# M25 junction 10/A3 Wisley interchange TR010030 9.5 DCO Application Errata Schedule

#### 9.5 DCO APPLICATION ERRATA SCHEDULE

<b>Regulation Number:</b>	Regulation 5(2)(q)
<b>Planning Inspectorate Scheme Reference</b>	TR010030
<b>Additional Submission Reference</b>	TR010030/AS-021 (2)
<b>Author:</b>	M25 junction 10/A3 Wisley interchange project team, Highways England and Atkins

SHEET **4** OF 31

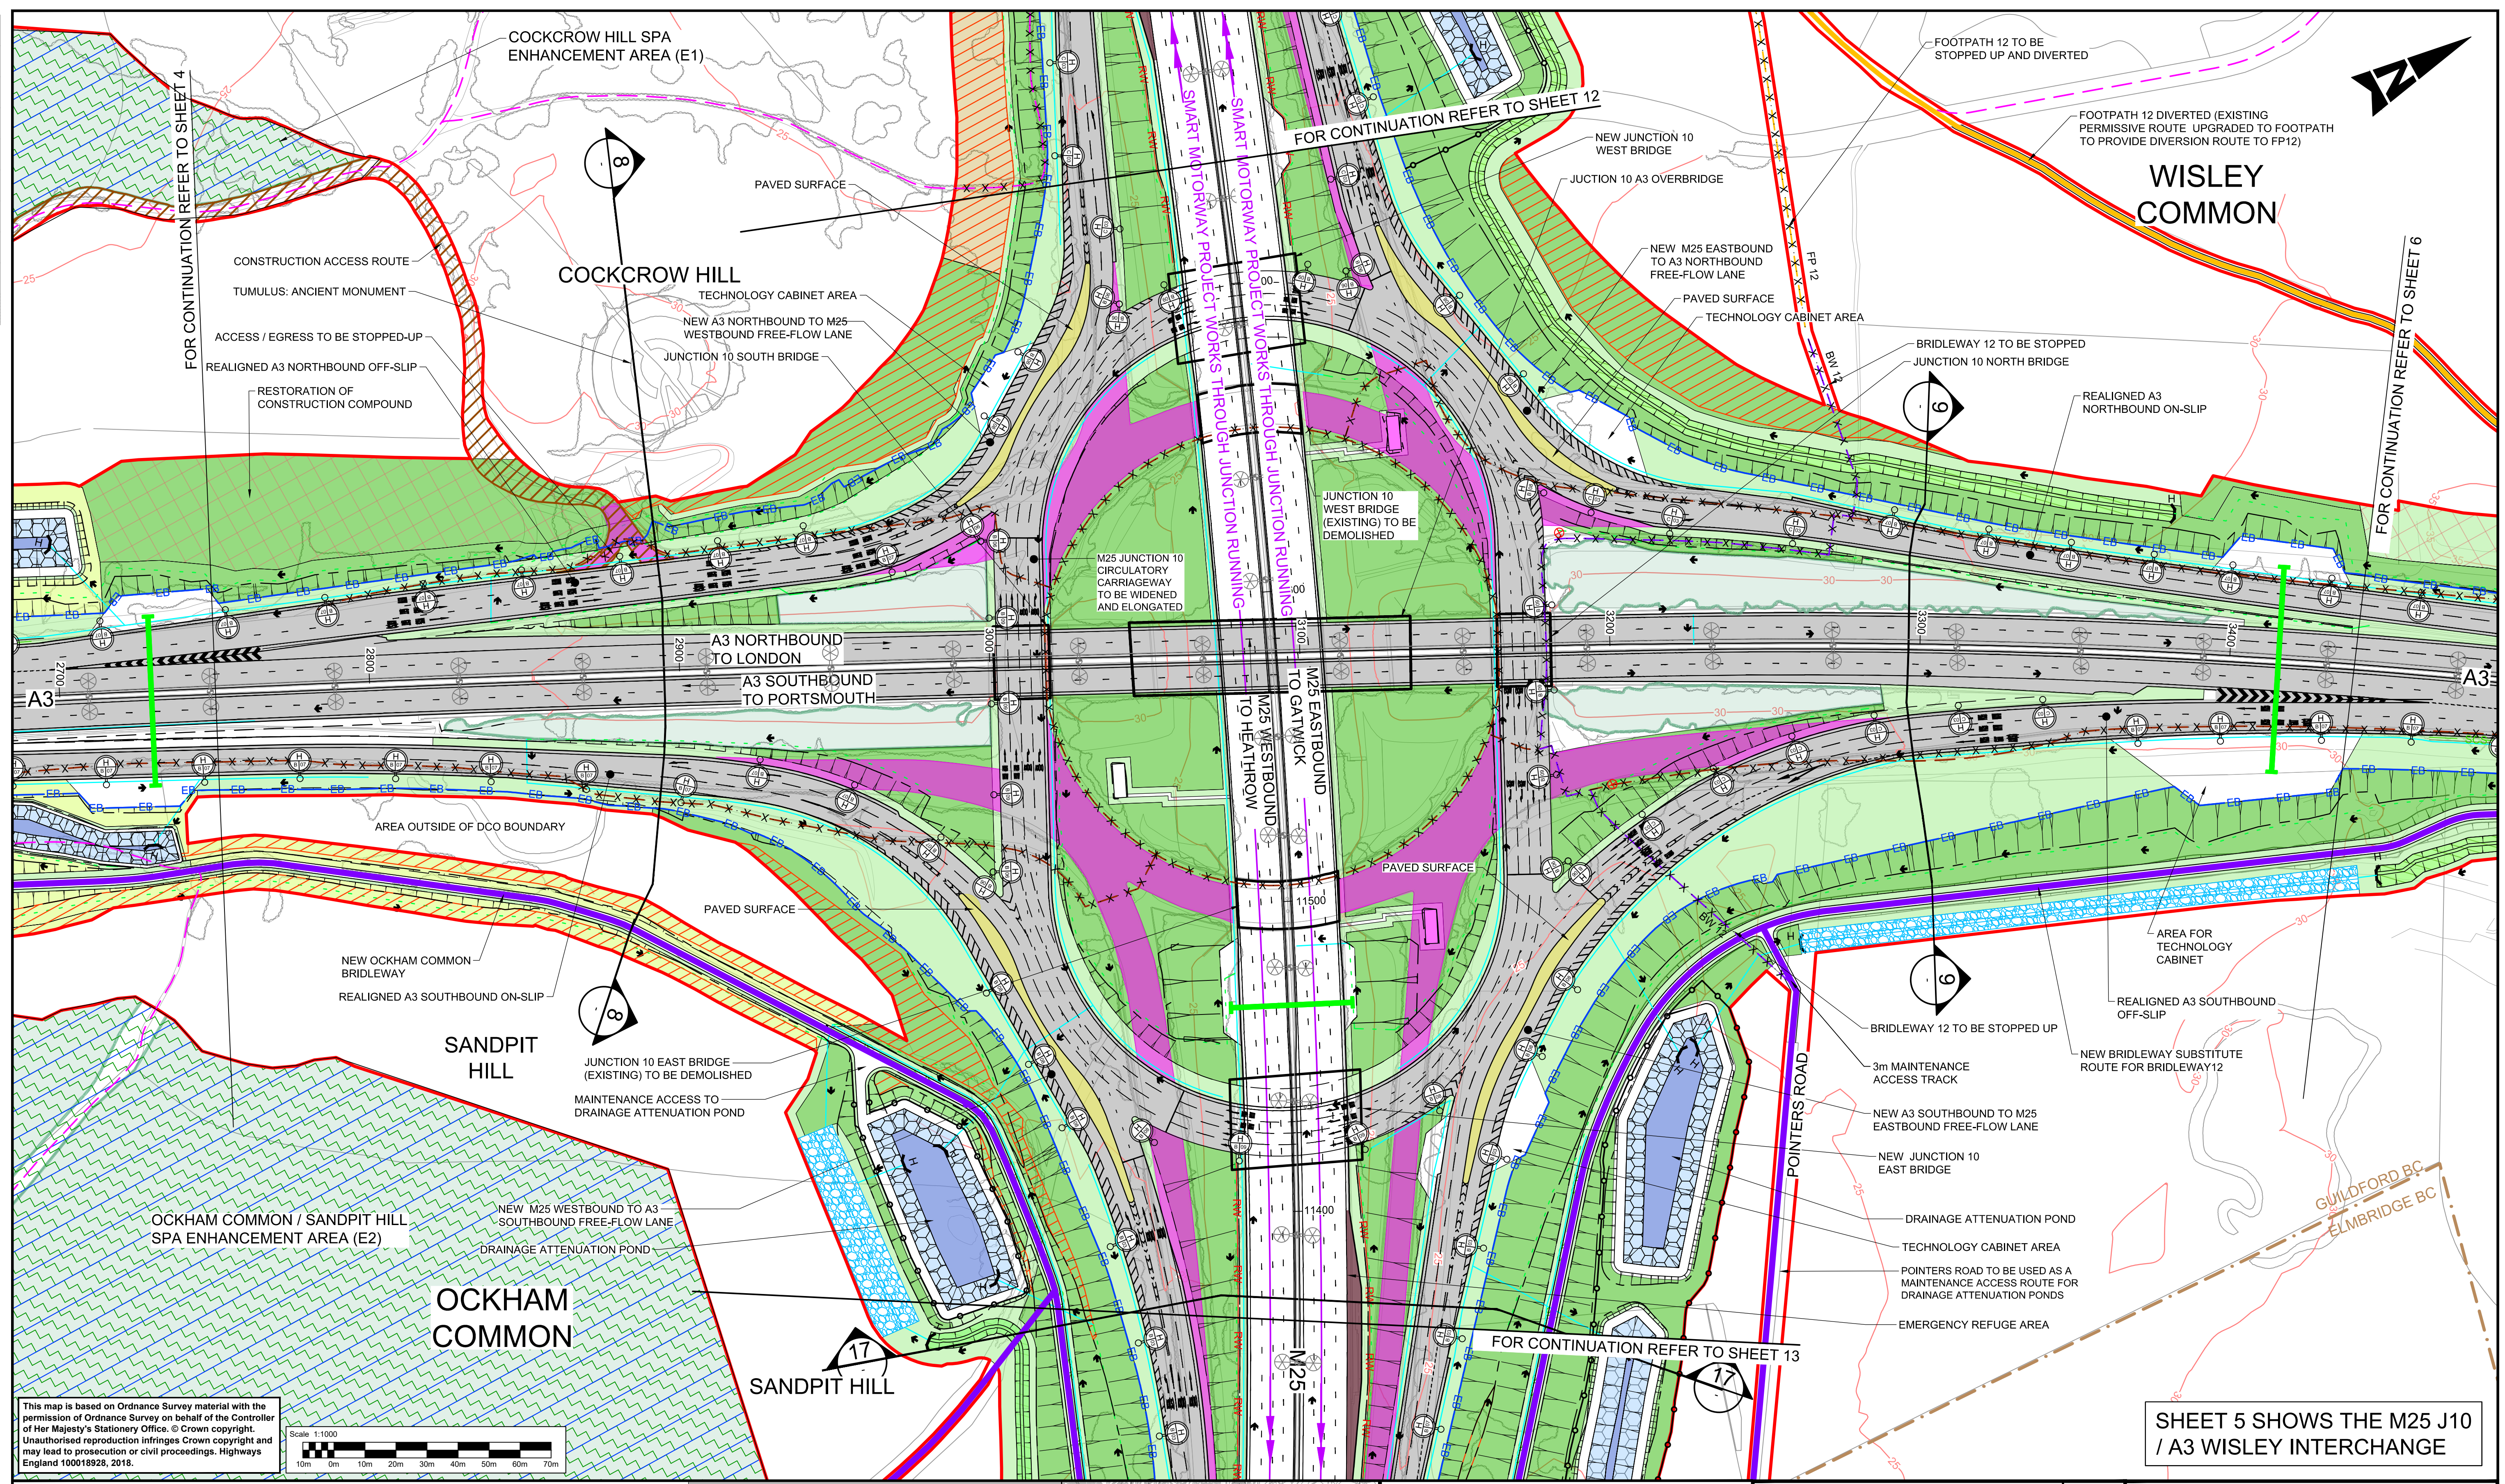
APP-012	2.8 Scheme Layout Plans	Sheet 4 of 31	The label reading "Existing access to Ockham Common car	Remove label

PINS Application Document Reference	Document name:	Section	Nature of Erratum and explanation	Correction
	(Sheets 1-10 of 31)		park/Ockham Bites café to be stopped up and reprovided” is incorrect and to be removed.	
APP-012	2.8 Scheme Layout Plans (Sheets 1-10 of 31)	Sheet 6 of 31	The hatched area marking the restoration of temporary possession land north east of the Gothic Tower incorrectly extends beyond the DCO boundary and to be removed.	Remove the hatched area which falls outside the DCO boundary.
APP-012	2.8 Scheme Layout Plans (Sheets 1-10 of 31)	Sheet 7 of 31	The label reading “New B365 Seven Hills Road extension” is incorrect and should be changed.	New private means of access and bridleway.
APP-012	2.8 Scheme Layout Plans (Sheets 1-10 of 31)	Sheet 7 of 31	The label reading “New Red Hill substitute access” is to be removed.	Remove label.
APP-012	2.8 Scheme Layout Plans (Sheets 11-31 of 31)	Sheet 11 of 31	The area of the scheme plan commensurate with Plot 11/11 incorrectly shown as SPA compensation land.	Change the scheme plan to remove this area from SPA compensation land.
